Subject: Pottinger Wind Farm – Response to Further Requests for Additional Information – TfNSW and BCS

We refer to the Department of Planning, Housing and Infrastructure's (DPHI) request for additional information regarding the Pottinger Wind Farm (SSD-59235464), in response to further RFIs from:

Pottinger Wind Farm
Cobb Highway / Wargam Road
Strategic Design - CHR(S)

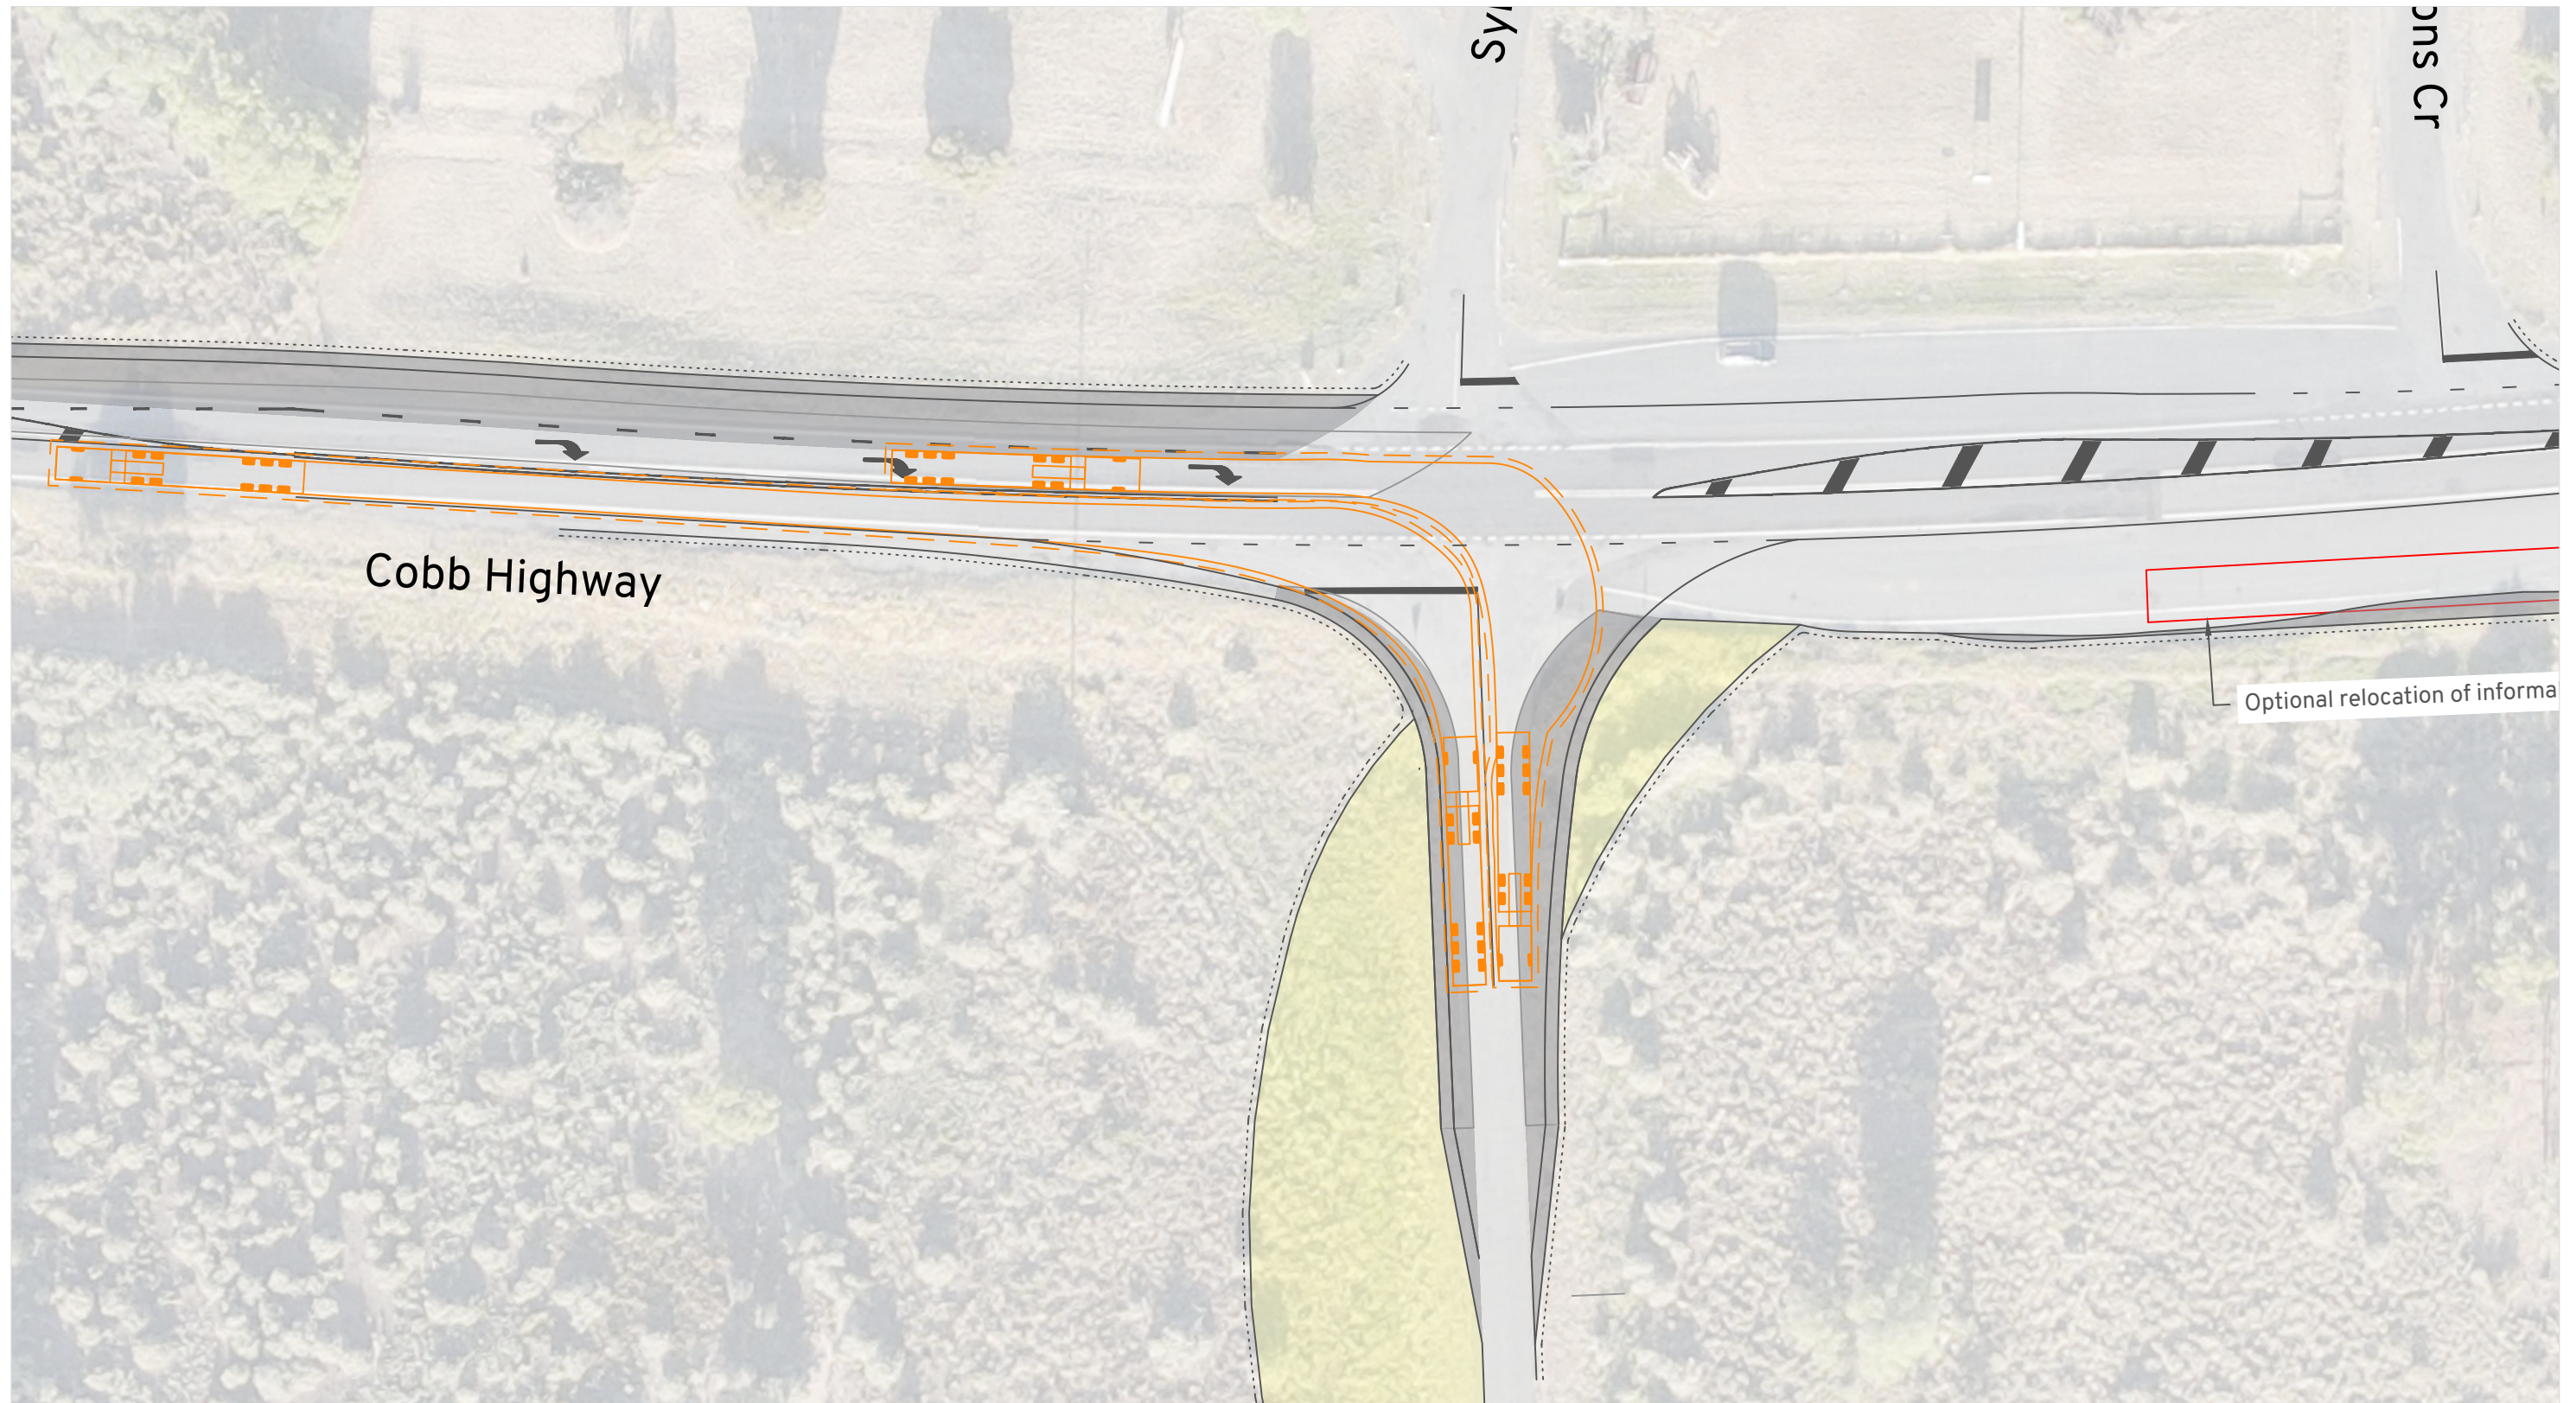
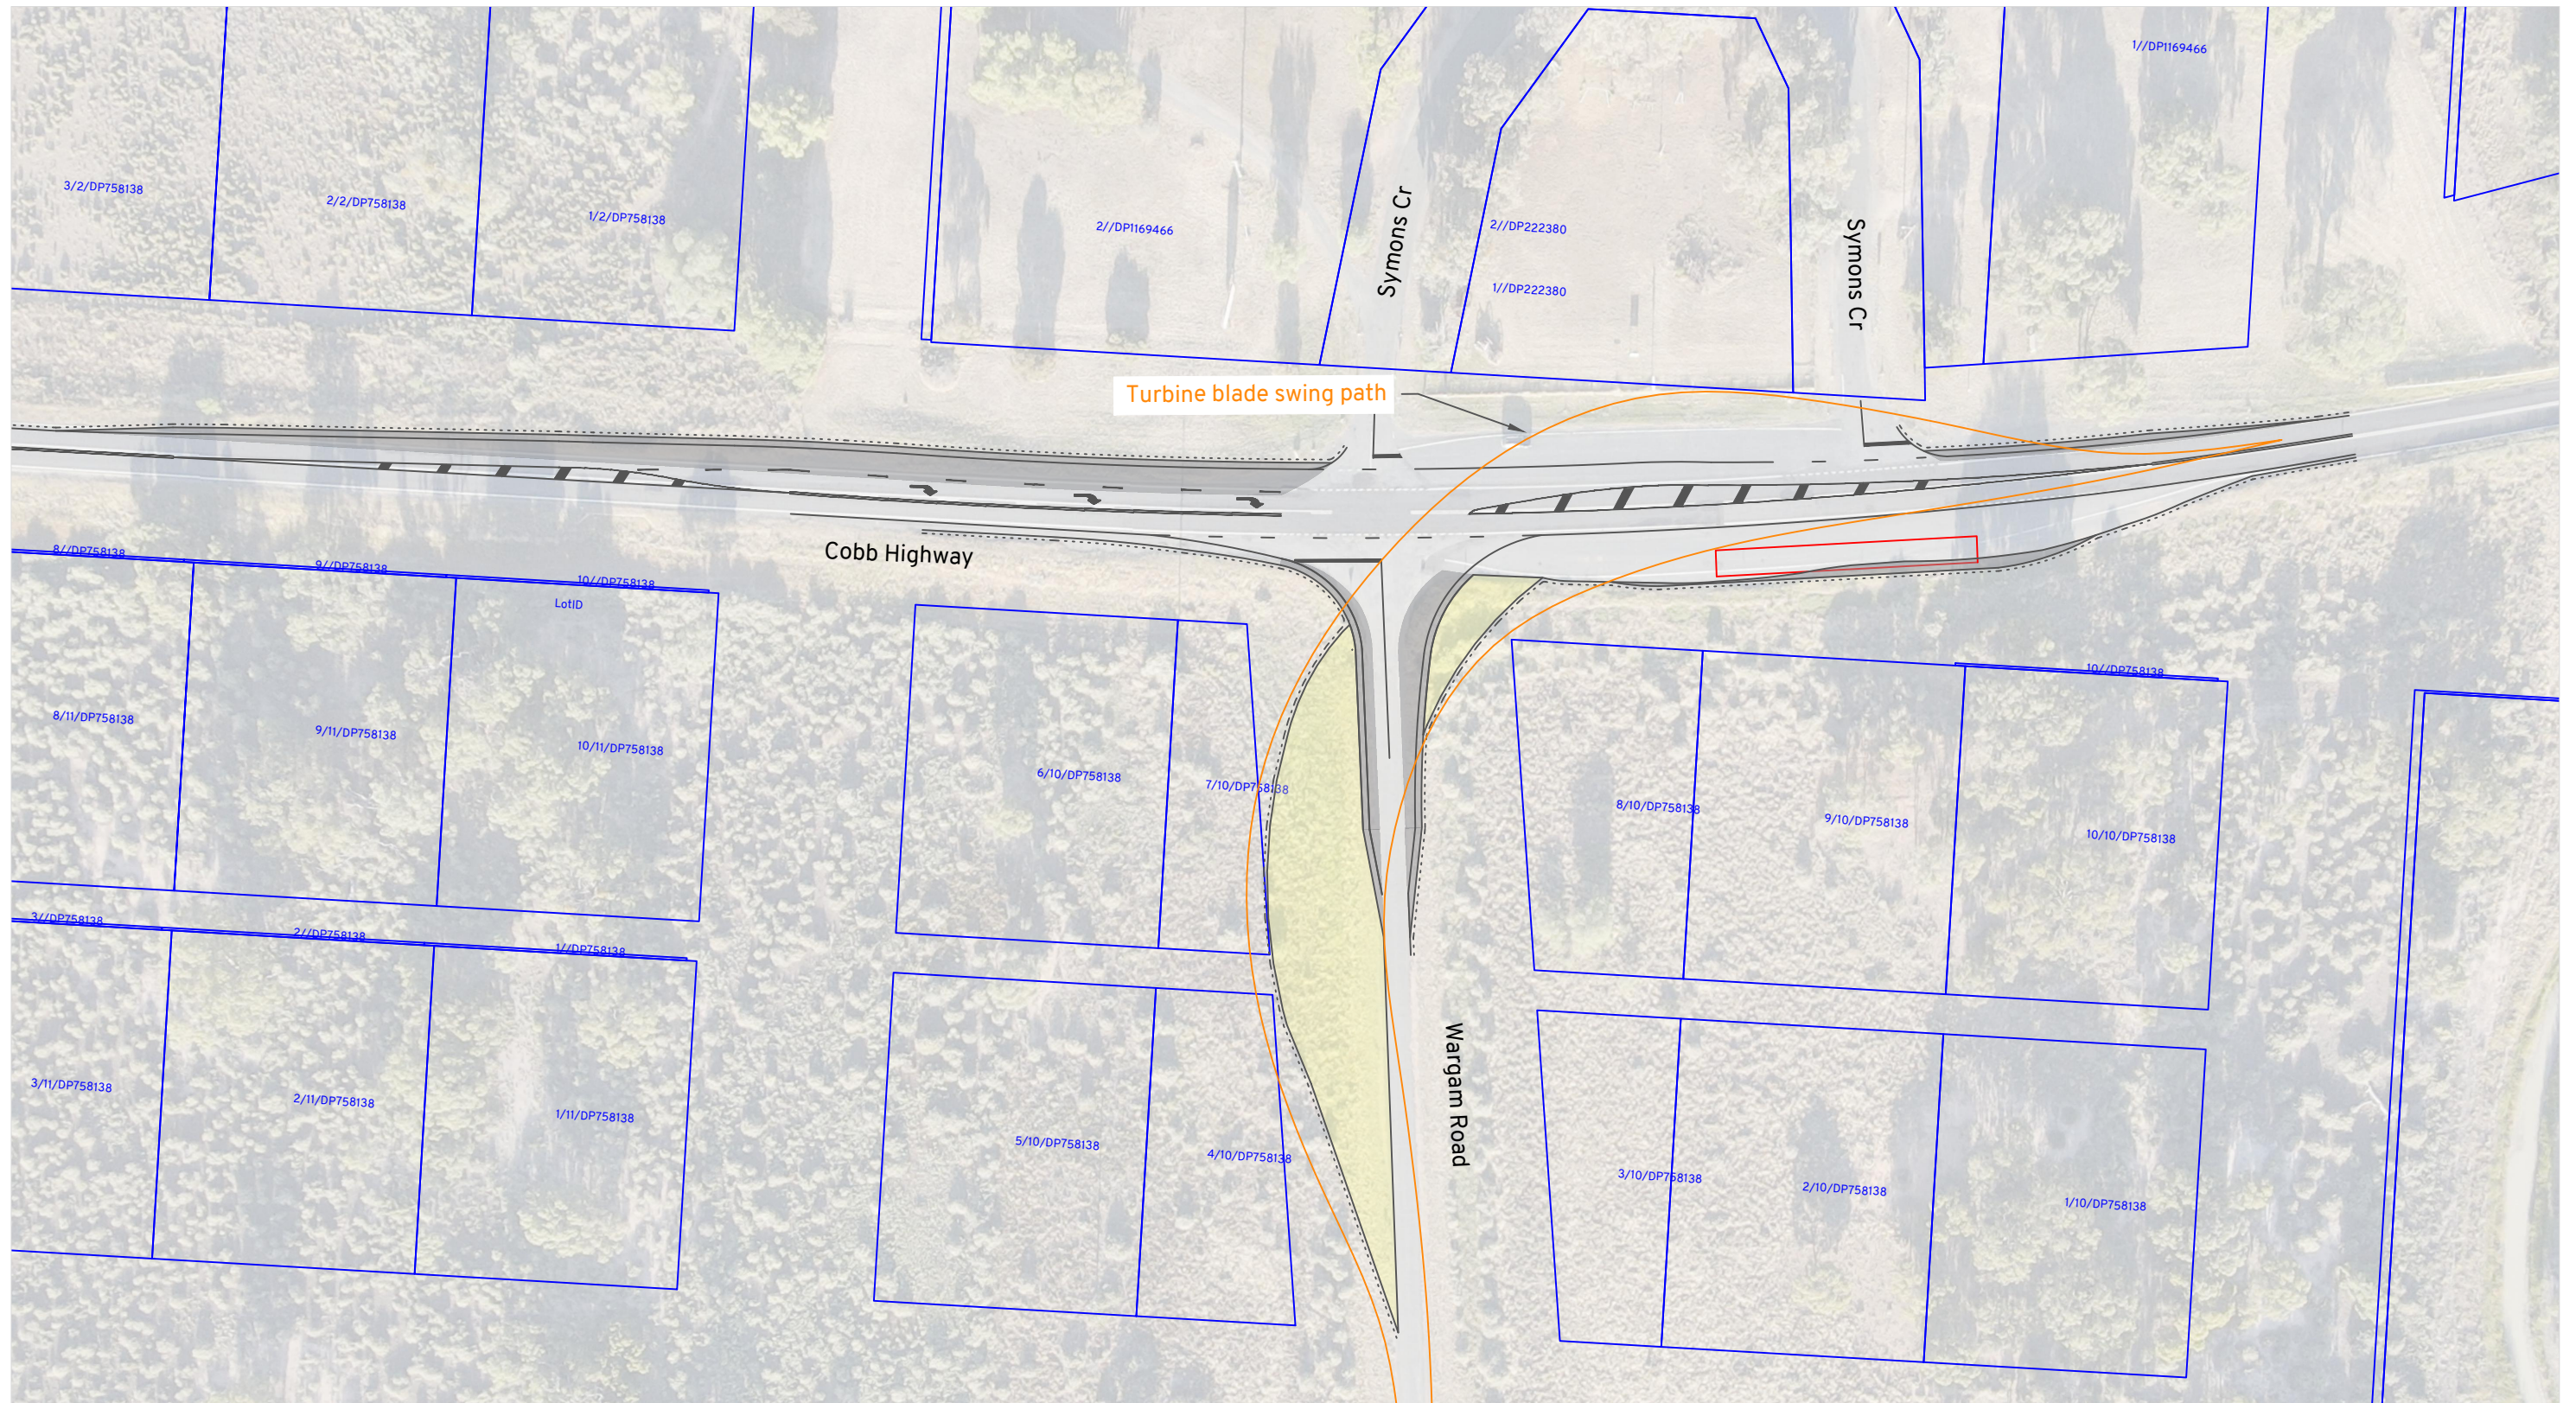
| Date | TfNSW request | Date | Response | Date | TfNSW Further Request | Date | Response |
|------------|---|------------|---|------------|---|----------|--|
| 16/01/2025 | Provide revised swept path diagrams with the wheel tracks shown. These are needed for key intersections identified for upgrades, as well as the intersections within Broken Hill (on Silver City Highway near Crystal and Chloride Street). | 17/1/2025 | Provided vehicle swept paths with wheel and load tracking on Silver City Highway near Crystal and Chloride Street. <u>Please see Appendix A for final document.</u> | 30/01/2025 | Regarding Appendix B • Page 8 – Chettle St/ Barrier Highway – no swept paths have been provided to show entry onto the Barrier Hwy. Swept paths for this needs to be provided for assessment. • Page 10 – 11 (option 1) – Cobb Hwy/ Sturt Hwy - Need to show the swept paths and how it is intended to navigate the raised islands on approach in order to travel in the northbound lane. - The swept path appears to show the OSOM vehicle running off the road on entry into the roundabout. Any widening to accommodate this needs to be identified on the design. - At the arrow “mountable kerb profile with concrete apron, reinstate if damaged”. It appears that the concrete apron would not be wide enough to support the OSOM movement. The concrete apron would need widening to support the wheel path. Please outline this on the design. - Design shows there is impact to lighting and power infrastructure. | 5/2/2025 | Provided swept path showing entry onto Barrier Hwy. <u>Please see page 8-9 in Appendix B for update.</u> Additional changes: -Swept paths showing how vehicle navigates the raised islands on approach to travel in the northbound lane. -Confirmed OSOM vehicle will stay on road on entry into roundabout. -Confirmed OSOM vehicle wheel path is expected to use mountable kerb profile with concrete apron and project would reinstate if damaged. -Used updated aerial imagery for Pinch Point 11 options 1 and 2 to give certainty to updated comments. -as per updated imagery, roundabout has already been upgraded with a mountable annulus. <u>See Appendix B for final document.</u> |

| Date | TfNSW request | Date | Response | Date | TfNSW Further Request | Date | Response |
|------------|---|------------|---|------------|---|----------|--|
| | | 23/01/2025 | Provided revised swept path diagrams with the wheel tracks shown for key intersections identified for upgrades. <u>Please see Appendix B and C for final document.</u> | | | | |
